**Erection of 2 No. 3 Bed Dwellings with off road parking and associated landscaping
Land at Entrance to Waterford Gardens, Horsemere Green Lane, Climping, BN17 5PQ
Planning Reference CM/18/19/PL**

23rd May 2019

**Erection of 2 No. 3 Bed Dwellings with off road parking and associated landscaping
Land at Entrance to Waterford Gardens, Horsemere Green Lane, Climping, BN17 5PQ
Planning Reference CM/18/19/PL. Case Officer Mr Z Denton**

drawing title:
Site Plan

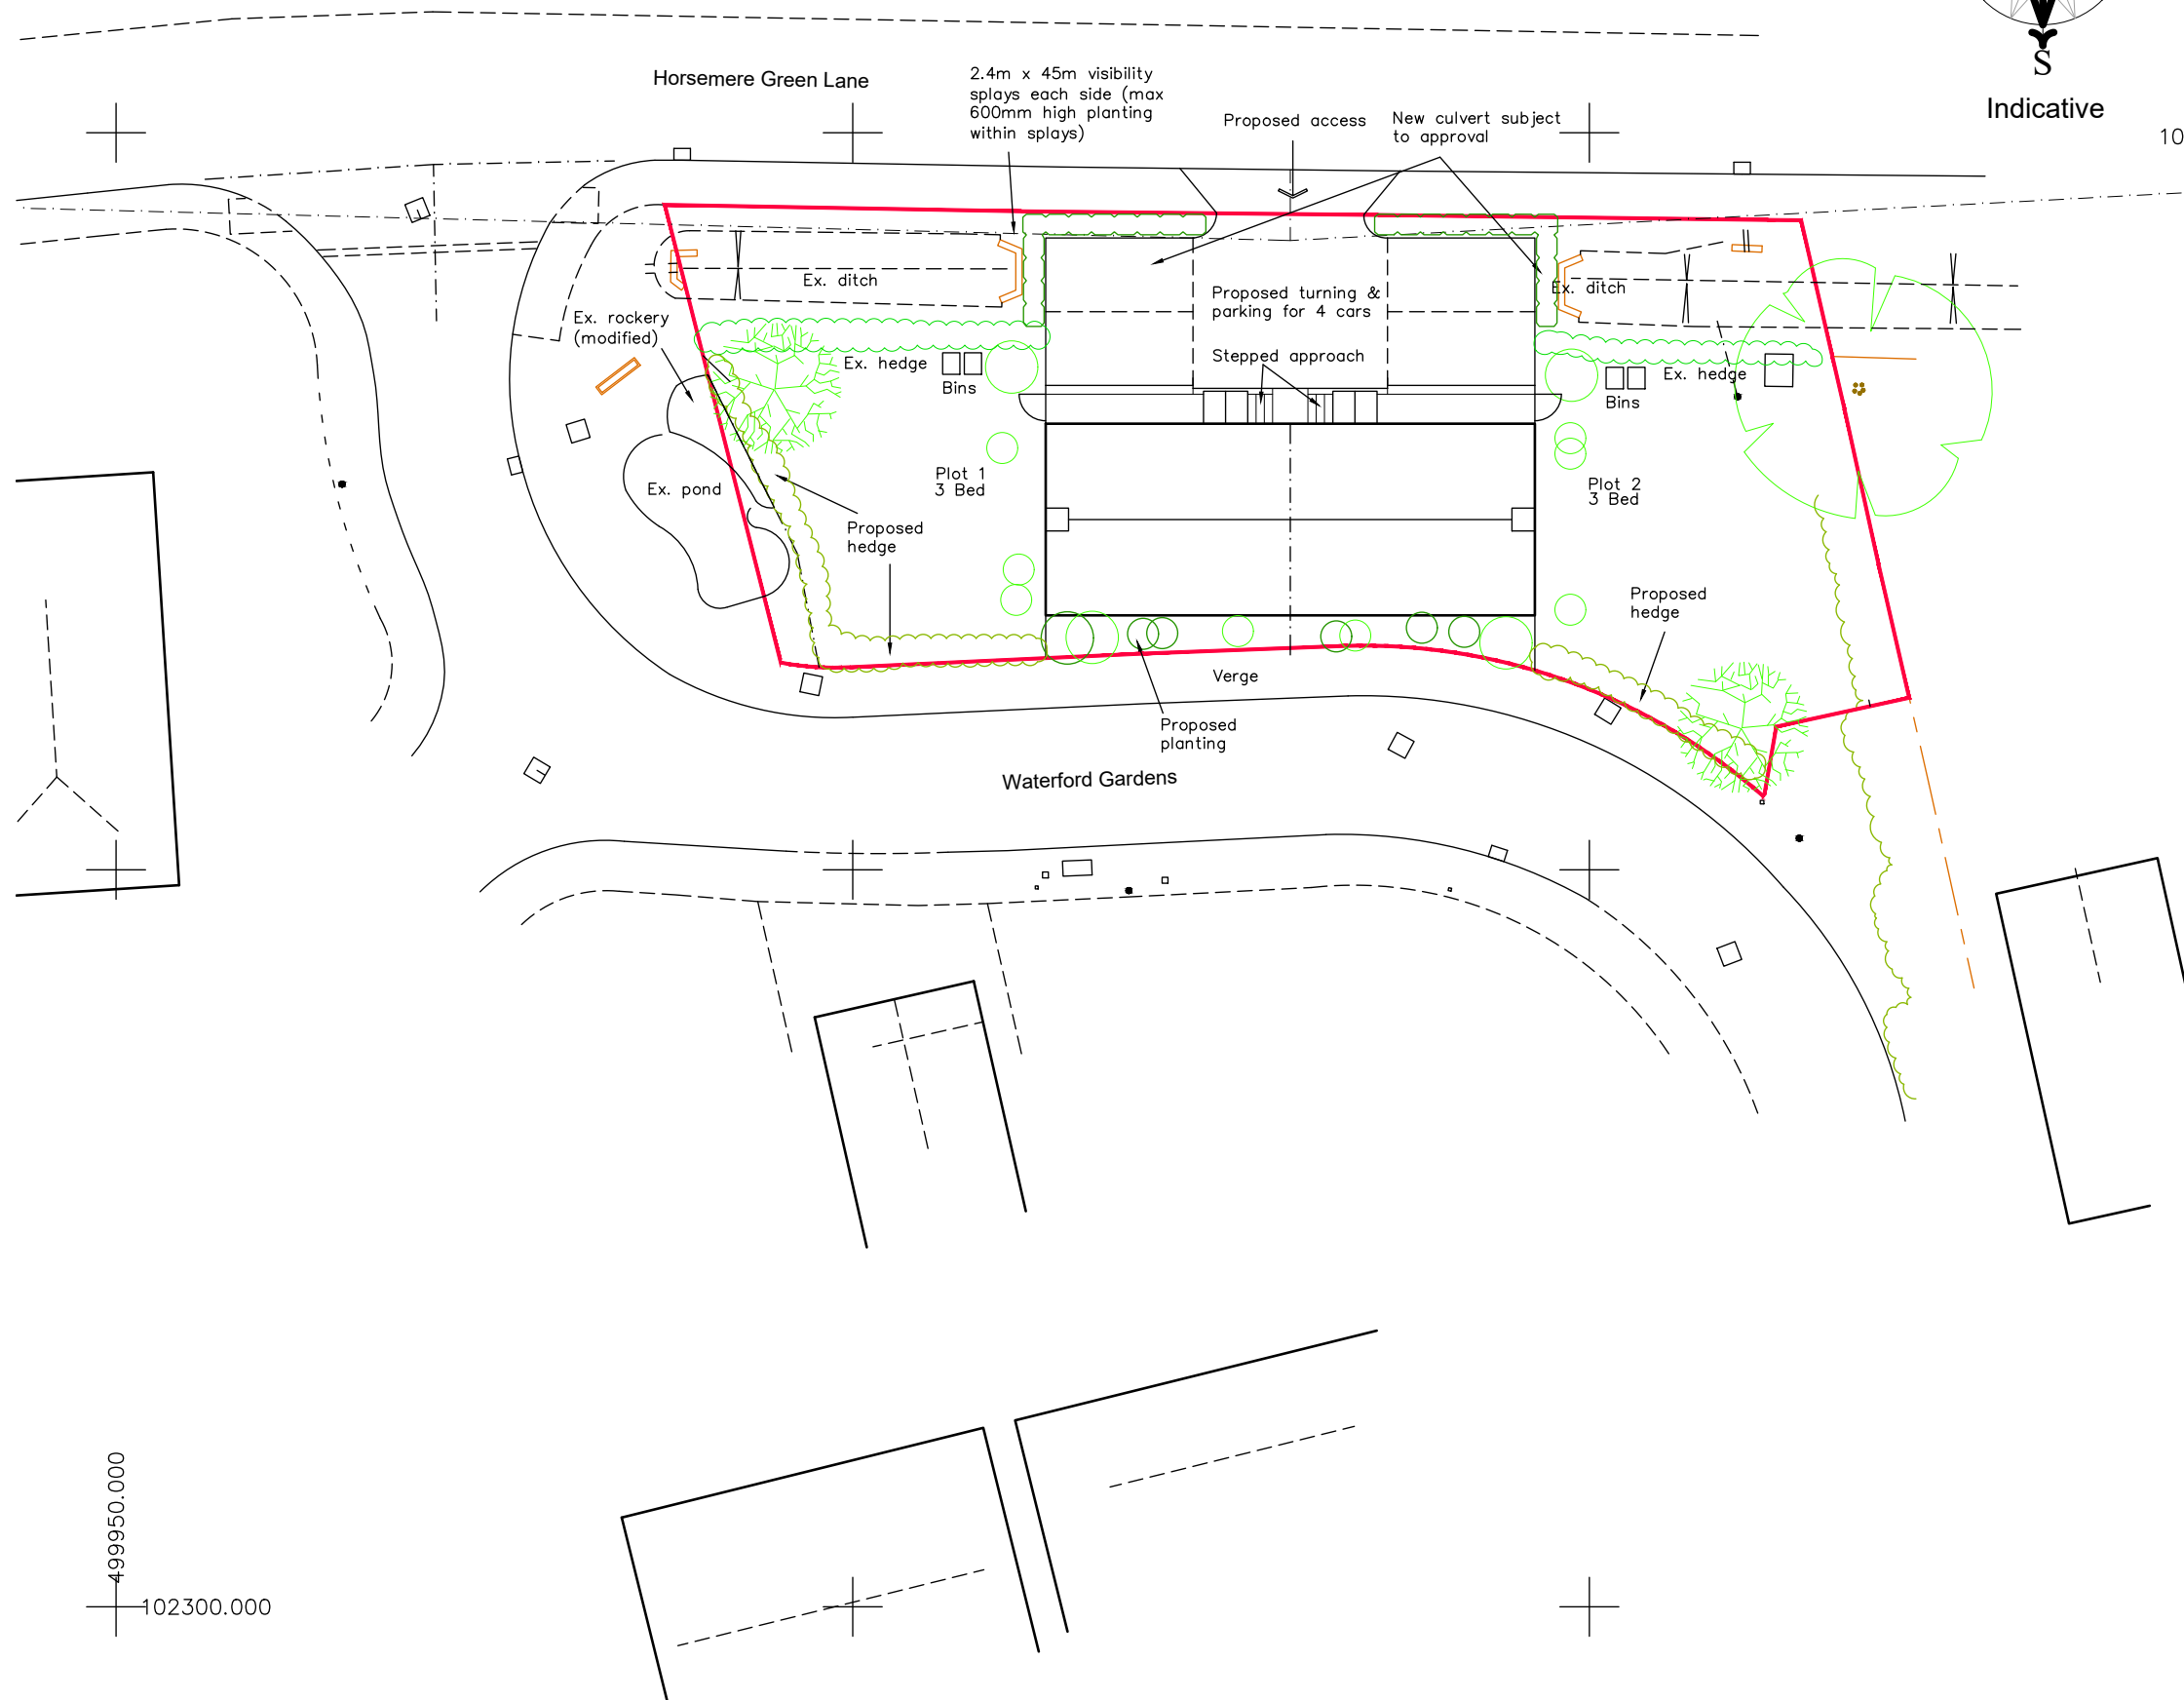
- 6) ADP Architects Drawing 1769/10/B indicates 2.4m x 45m visibility splays each side (max 600mm high planting within splay), how are these going to be constructed as they are on Land not owned or in the control of the Developer. Again, this is a false illustration and is highly misleading to the Planning Authority.

- 8) ADP Architects Drawing 1769/10/B indicates Soft Landscaping and Hedging, but we highlight none of the Existing Planting, Hedges, Bushes, Trees and or their roots on the Boundary of the Development Site with the Boundary of 29 Crophorne Drive are currently maintained by the Developer and are all overgrown to the point where fencing is being damaged so we question how the Developer will plant and maintain any Soft Landscaping and Planting as no actual maintenance or maintenance plan is currently in place.

Proposed Elevations

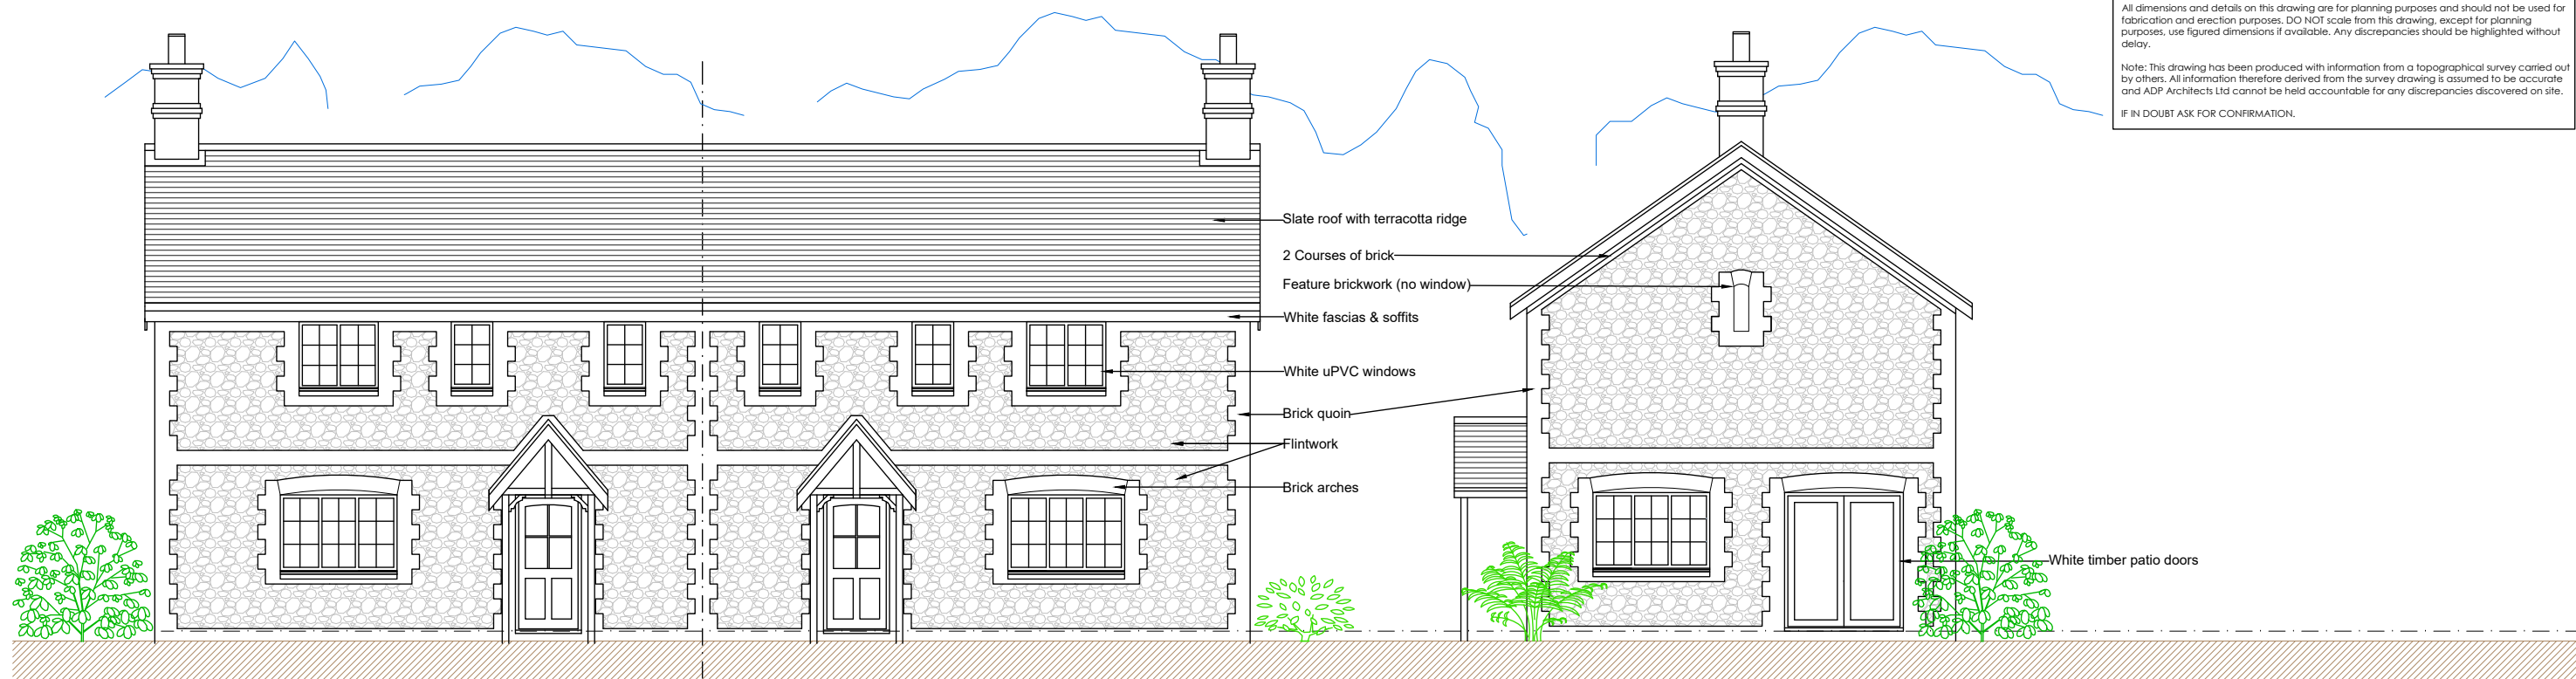
- 9) ADP Architects Drawing 1769/12/D includes no levels or heights of buildings and chimneys.
- 10) ADP Architects Drawing 1769/12/D makes no reference to Obscure Windows to Bathrooms or Windows that directly overlook other properties.

TITLE Existing Site Layout	
SCALE 1:200	PROJECT No. 23078
REPORT TYPE DS	DWG. No. 02

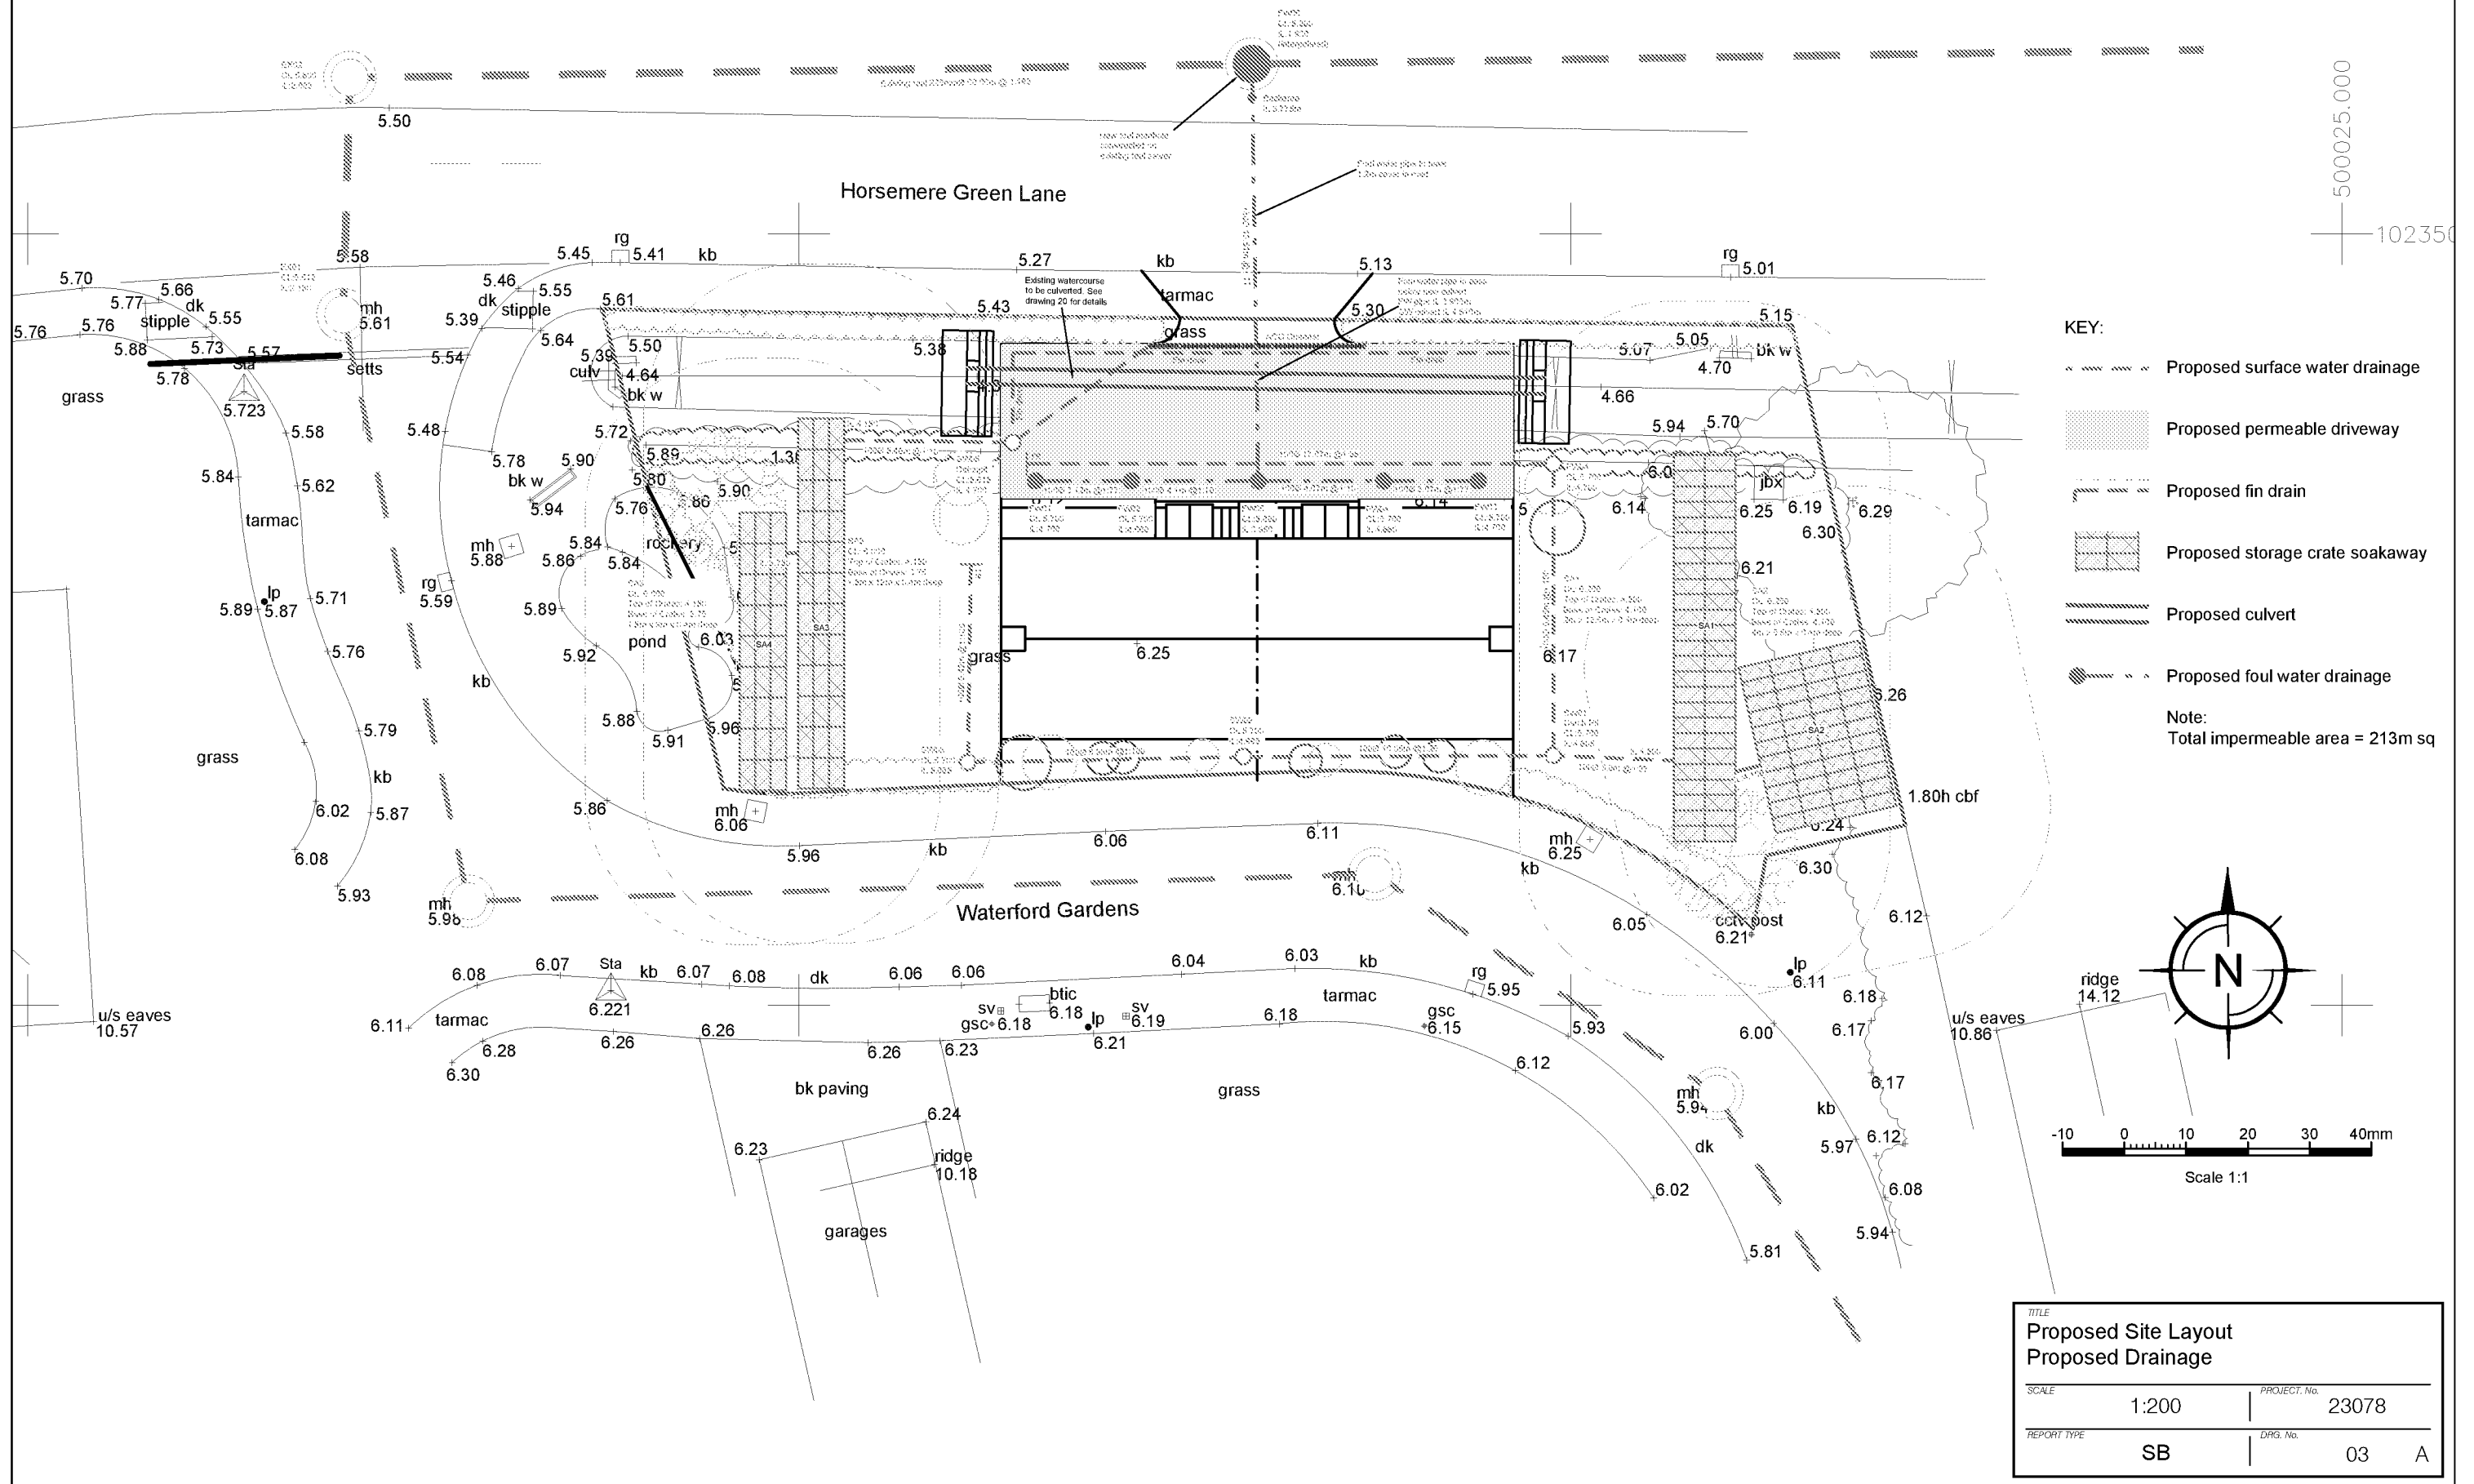
- 3) Planning Application CM18/19/PL does not include any Ground Investigation or Soil Report.
- 4) The Civil Engineering Practice Drawing 23078/03/A appears to indicate the whole Development Site and Parking being built past the Existing Boundary Fence and Hedge up to the Public Footpath on Horsemere Green Lane which is on Land not owned or in the control of the Developer. This is a false illustration and is highly misleading to the Planning Authority.

- 5) The Civil Engineering Practice Drawing 23078/03/A indicates Drainage Storage Crates being installed immediately adjacent and on the Boundary of 29 Crophorne Drive which will undermine and affect existing land, structures, fencing and planting owned by 29 Crophorne Drive.

- 11) The Civil Engineer Practice Drawing 23078/03/A refers to 'Existing Watercourse to be Culverted. See Drawing 20 for detail' and yet Drawing 20 is missing from the Planning Application.
